Application No: EP/124/20/HH
Site Address: Little Dormers 23 Upper Drive East Preston BN16 1QN
Description of works: New bay and porch skirt roof to the front elevation, and roof linked detached double garage.

Thank you for your internet representation made on 30th November 2020 which has been recorded as an objection with the comments as follows:

OWPC31795

Location Plan and Block Plan

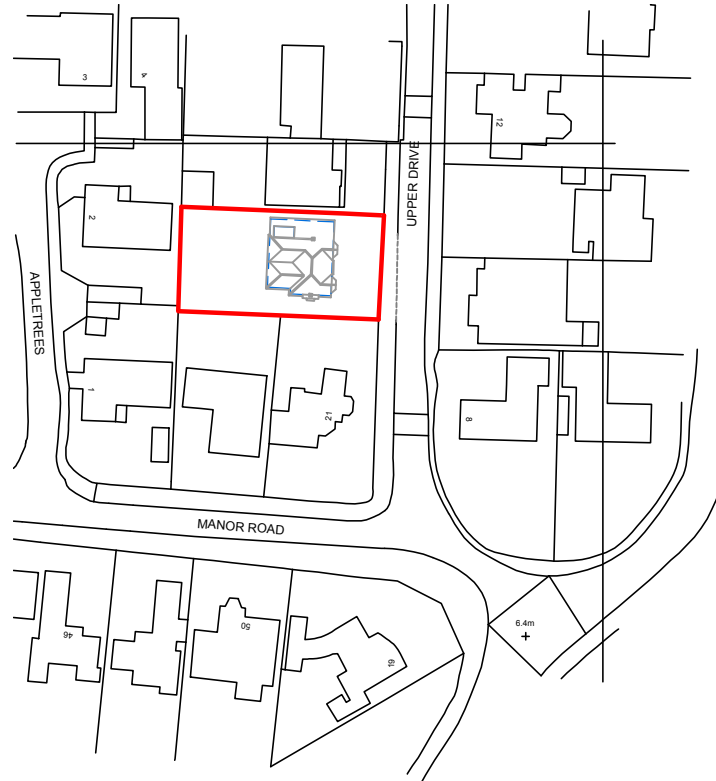
We live next door to the immediate south of the property subject to this application and have done so for almost 19 years. We are in our 80's and rely on being safe when we drive out onto Upper Drive from our home. The proposed garage would severely block our view to the north in Upper Drive and thereby be a danger not only to ourselves but also to other users of Upper Drive. The scale and density of the proposed garage is vast and would negatively impact the aesthetic pleasure, look and design of Upper Drive. It would massively infringe on the general building line of the properties along our side of the road (westside). Furthermore it would cause a loss of light to No.25
